SUBJECT: SFD2208-0061
SINGLE FAMILY DWELLING

Here are the results of all Inspections located at **5210 OLD US 421:**

FOUNDATION PLAN

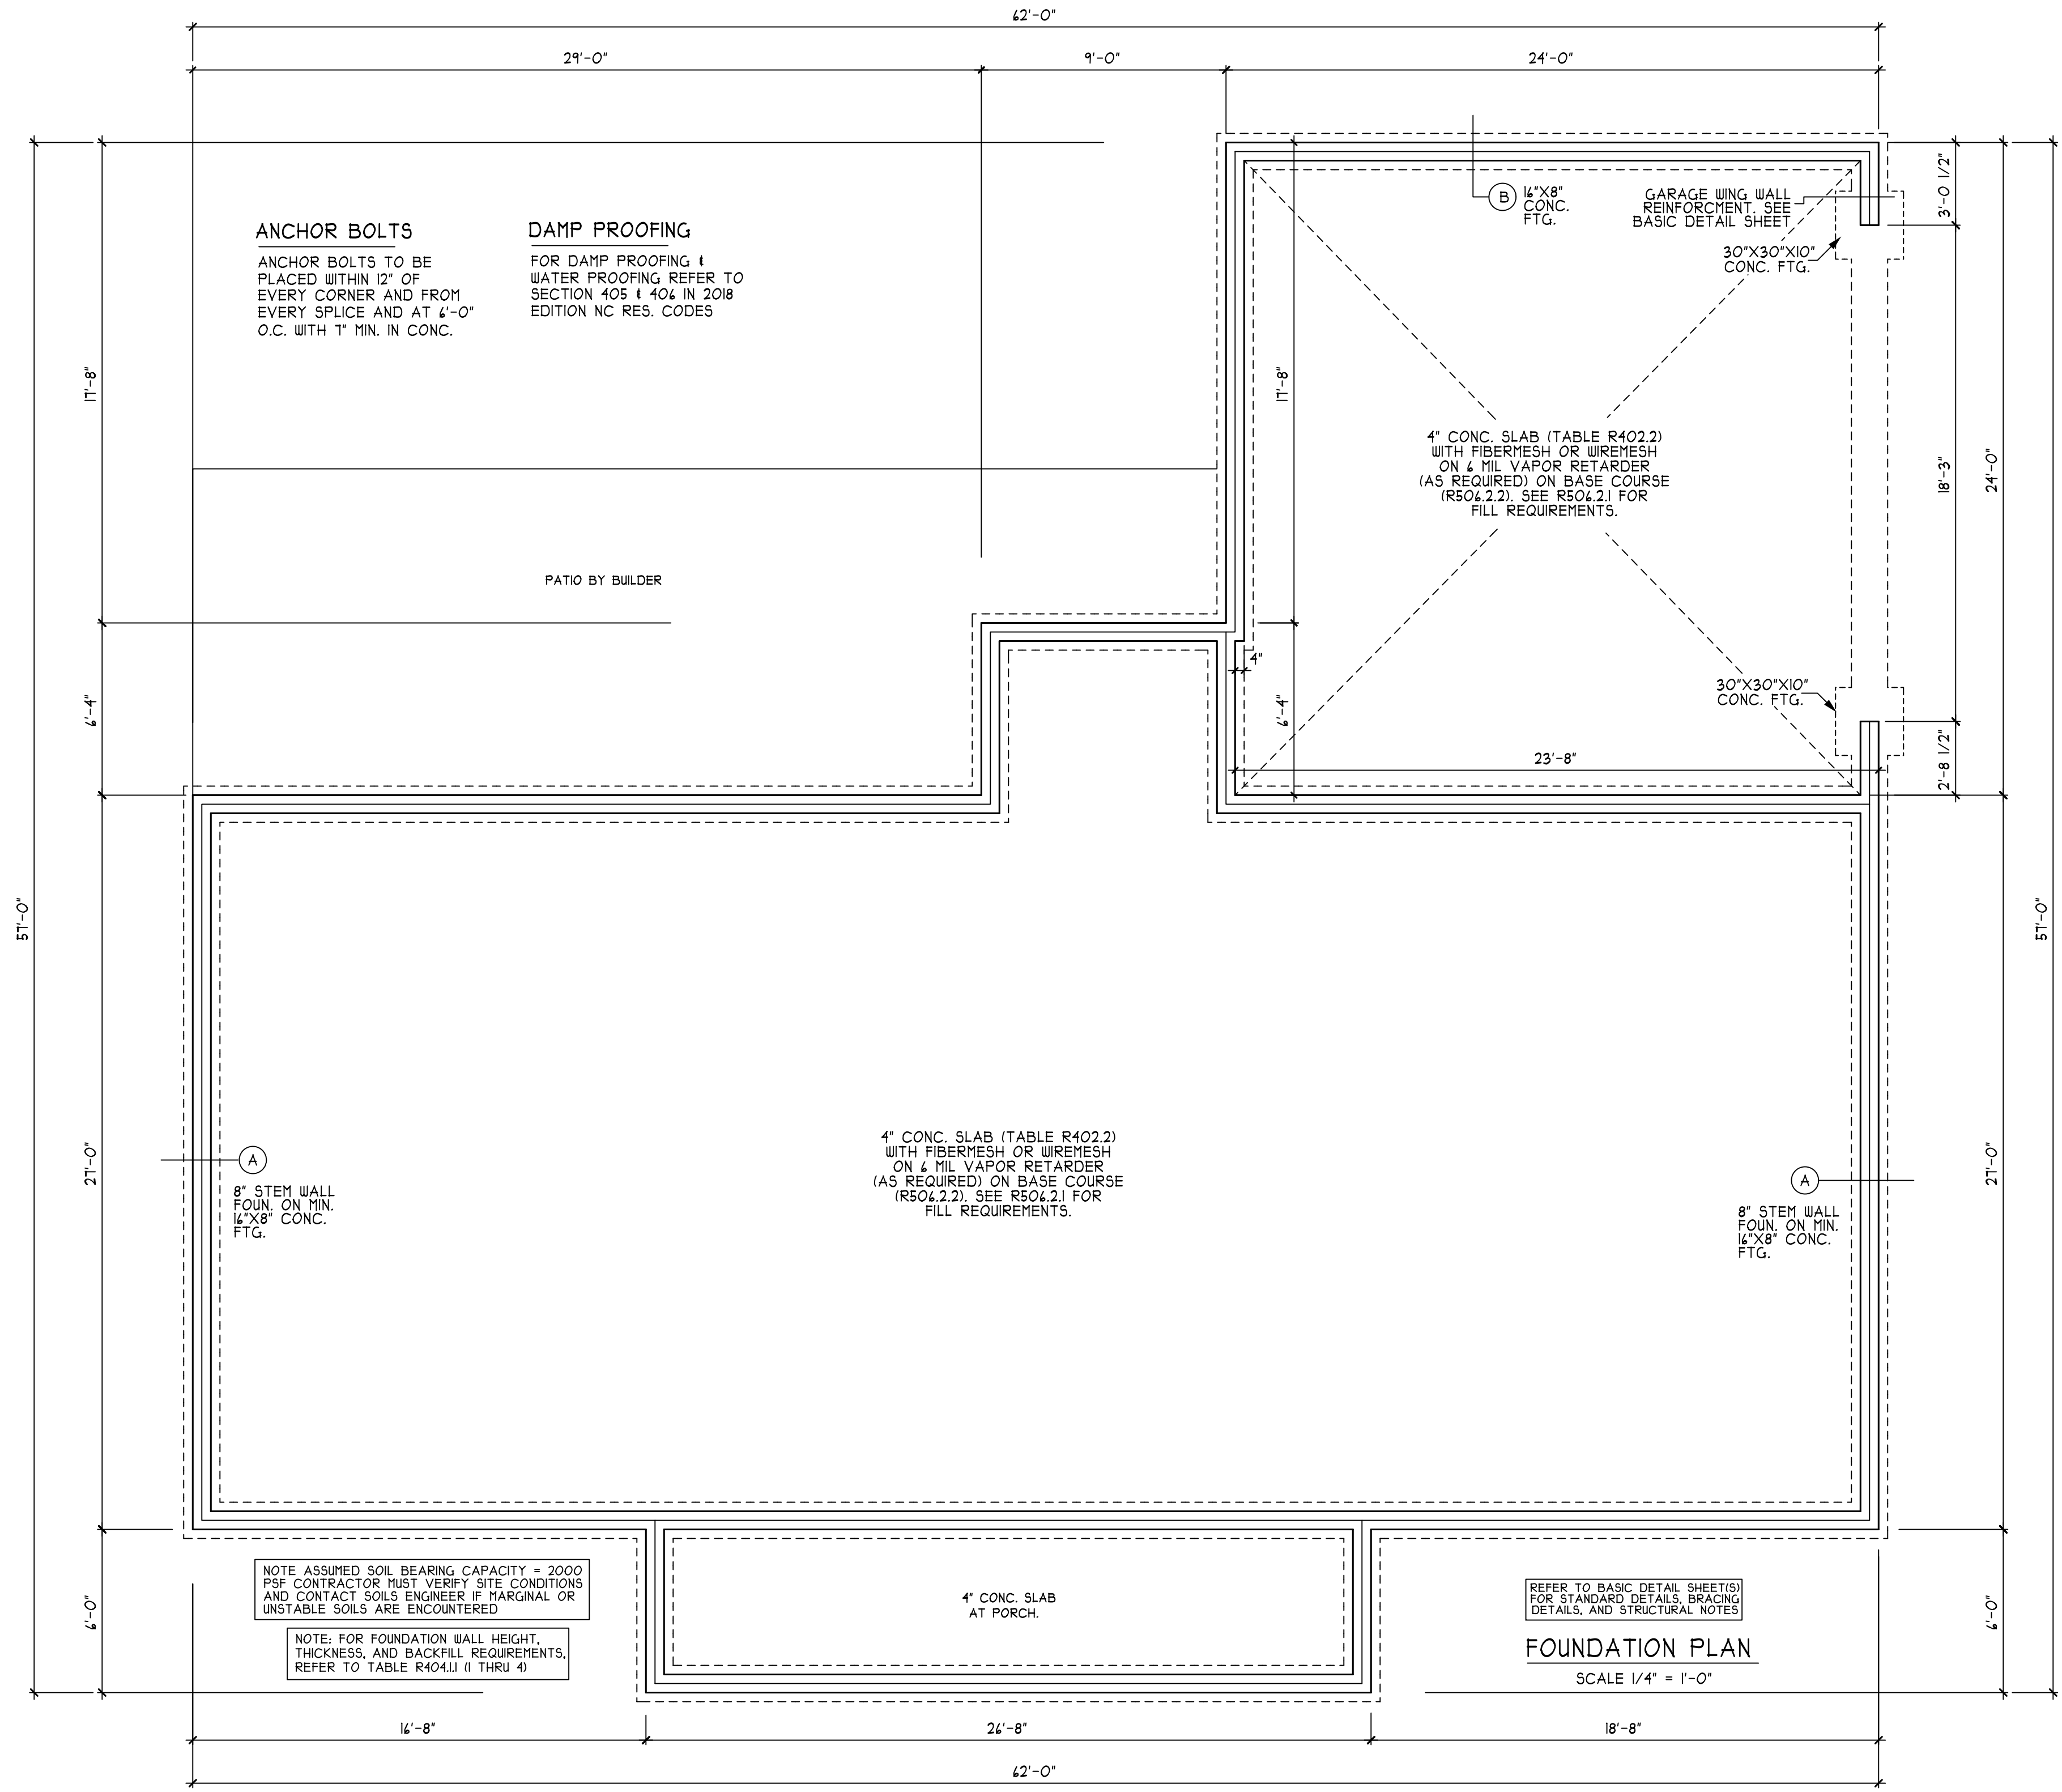
Missing anchor bolts, need two per plate and 12 inches from corner of house. Missing garage wing wall 2" square washers. Add cripple stud under plate break above garage door. Plumbing pressure test down. Seal top of laundry wall. Missing toilet flanges. No plumbing drain test. Seal pipes to slab at tub. missing insulation stops and baffles. Missing porch post and attachment. Tape vertical seems of housewrap.

FIGURE R602.10.3.3 METHOD PFH: PORTAL FRAME WITH HOLD-DOWNS

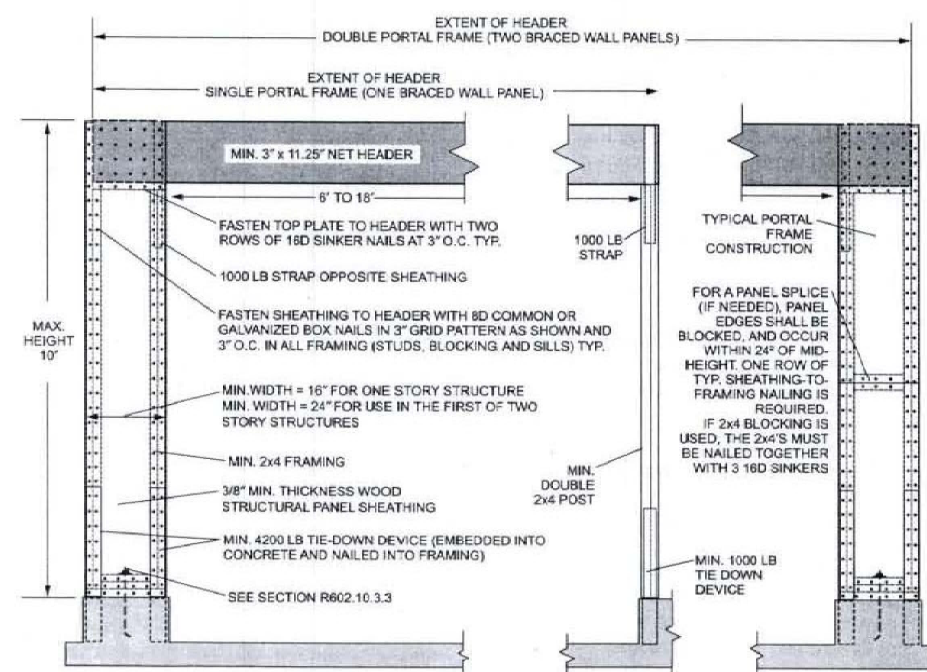
Inspection Type: ROUGH IN REINSPECT
Scheduled Date/Time: 10/9/2023
Completed Date/Time: 10/9/2023
Inspector: John B Kokoszka
Result: DISAPPROVED
Remarks:
Notes: Missing portal framing bolts and 2x2 washer at garage Need 100 psi on water line testMissing front porch connection. All from previous inspection
